Town & Country Planning Act 1990 (as amended)
Town & Country Planning (Development Management Procedure) (England) Order 2015

Demolition of existing garage & outbuildings. Alterations to external materials (including change from thatch to clay tiled roof and brick/stone to fibre cement weatherboarding and coloured render). Alterations to existing fenestration, including to 2 no. ground floor rear bay windows, and addition of first floor front dormer, enlarged balcony at first floor level at the rear. Replacement garages.

The Breakers 29 Tamarisk Way East Preston

Thank you for your internet representation made on 7th February 2020 which has been recorded as **'an objection'** with the comments as follows:

REV	DATE	DESCRIPTION
A	09.10.19	Revised to South Elevation. Dormer added and cladding altered to North Elevation.
B	04.11.19	Planning Issue
C	25.11.19	North Elevation cladding added Issued for Planning

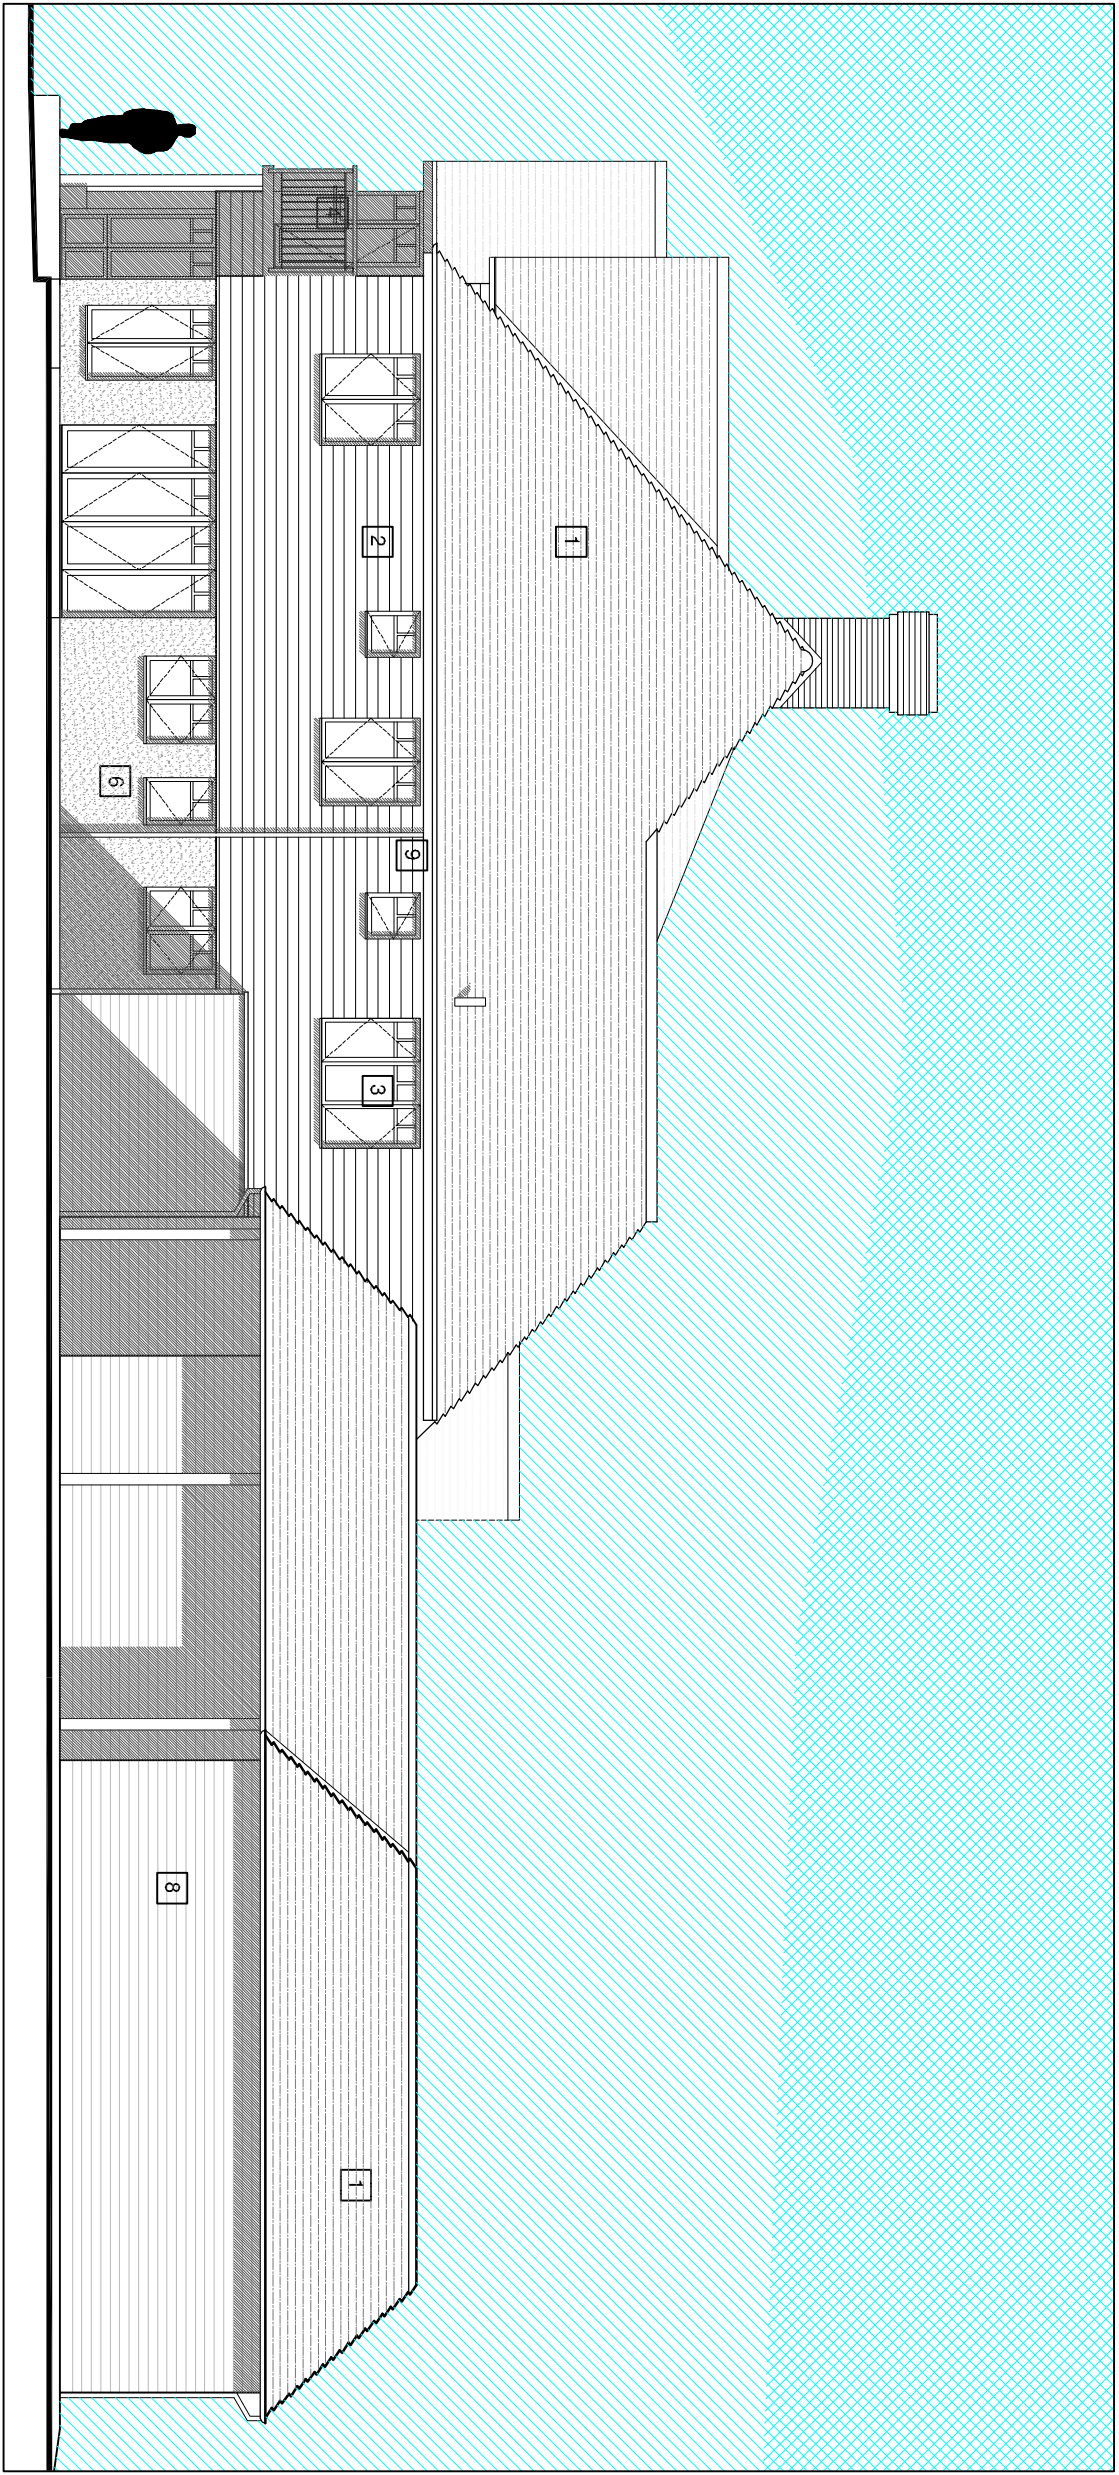
This proposal will destroy the character, not only of number 29 but the western end of Tamarisk Way as well.

The Breakers, 29 Tamarisk Way, East Preston Boundary Wall and Gates as Proposed

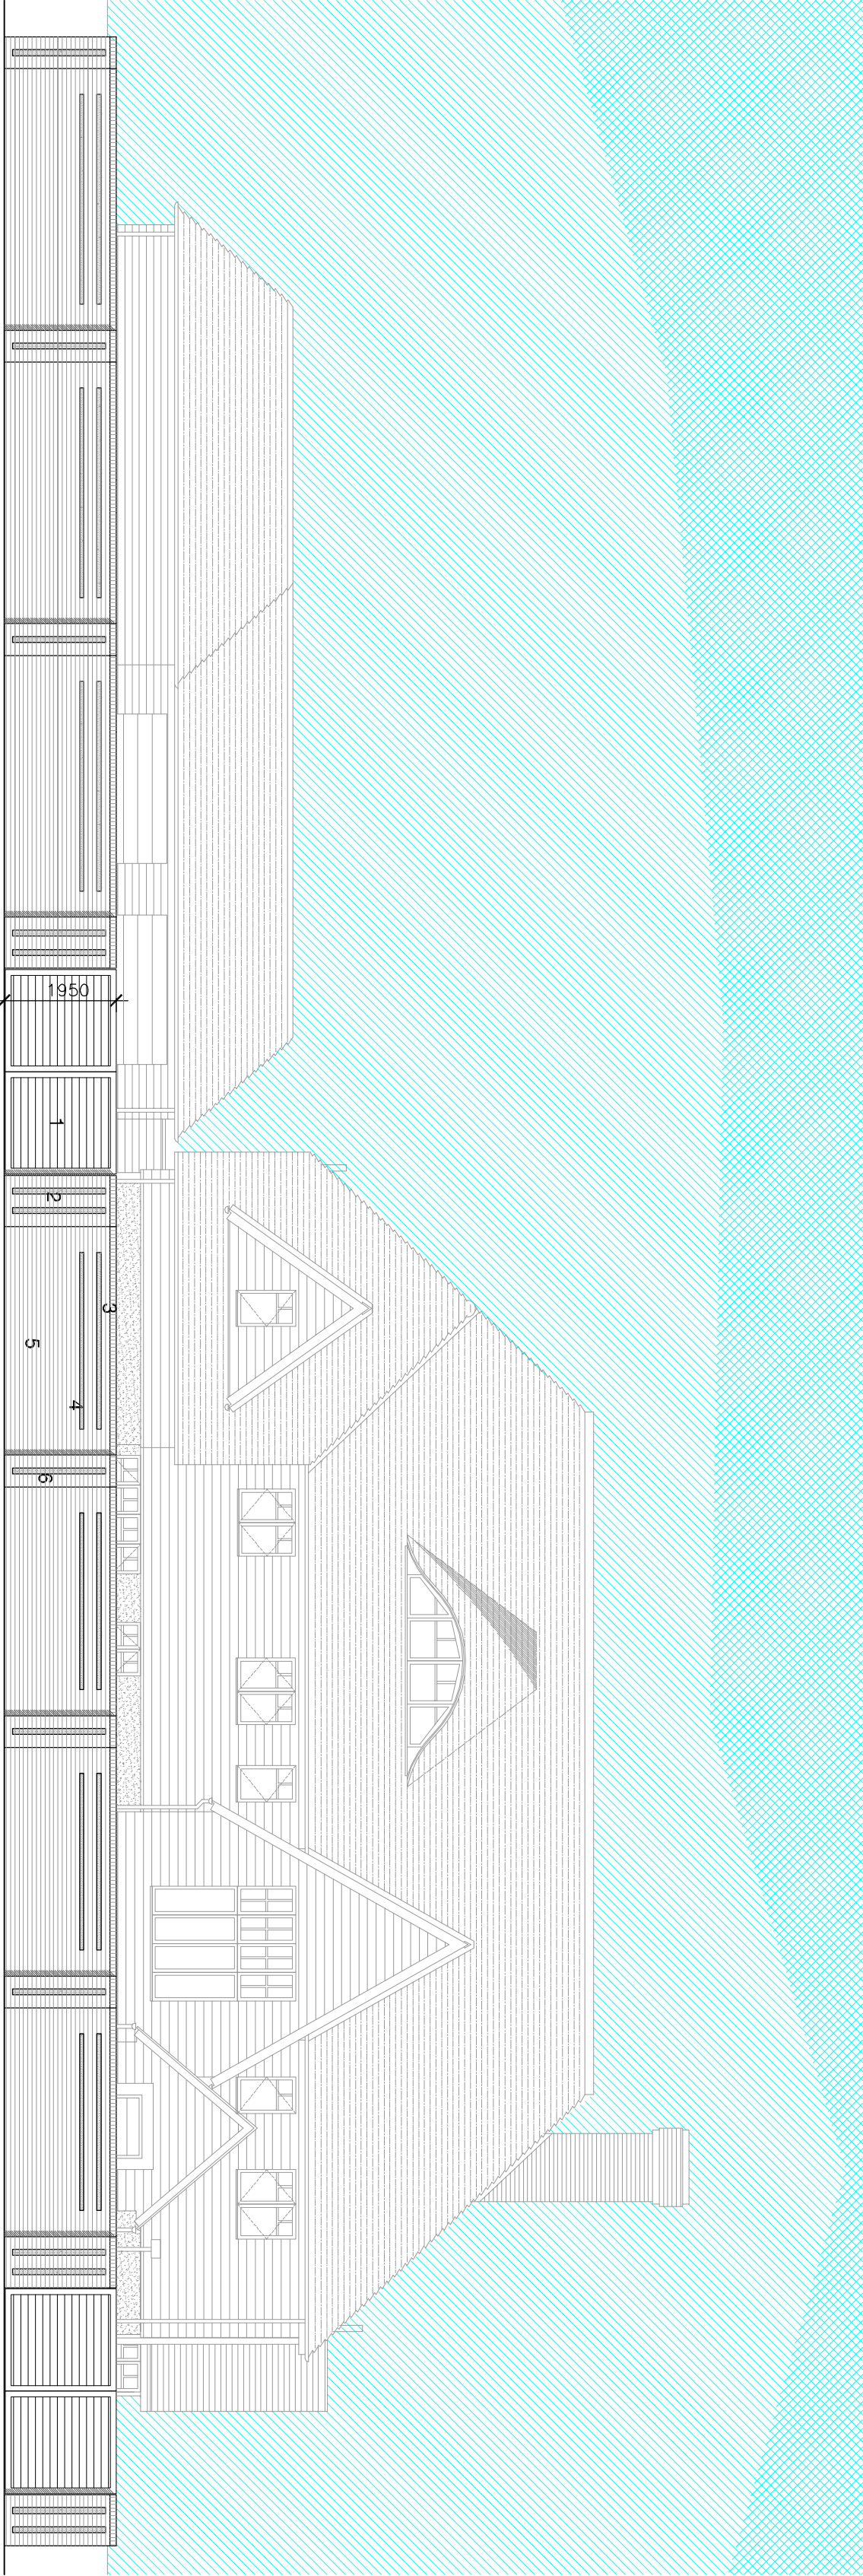
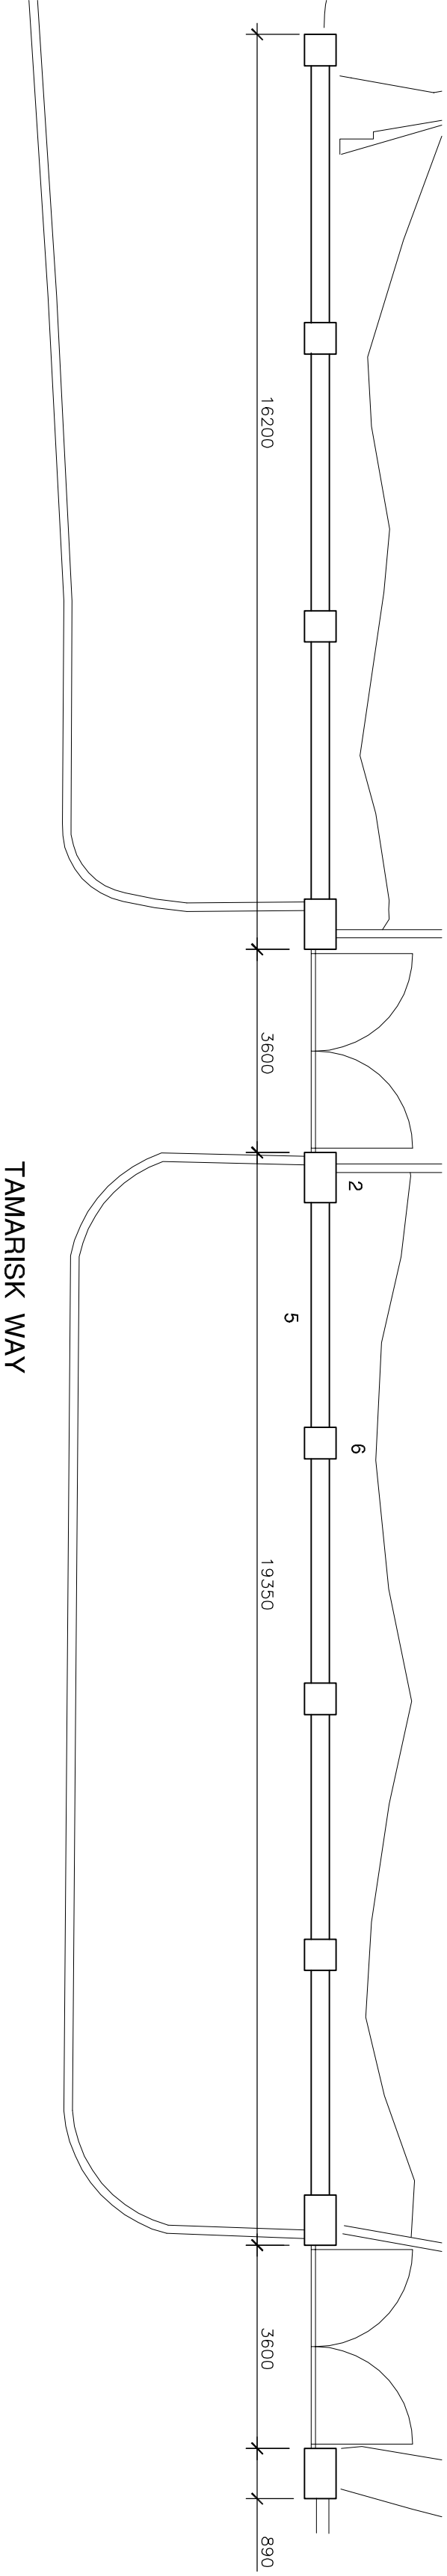
I particularly object to the garage extension which would be directly in front of my living room and bedroom windows and the proposed solid 2m high wall replacing the existing character boundary wall and railings which complement the property.
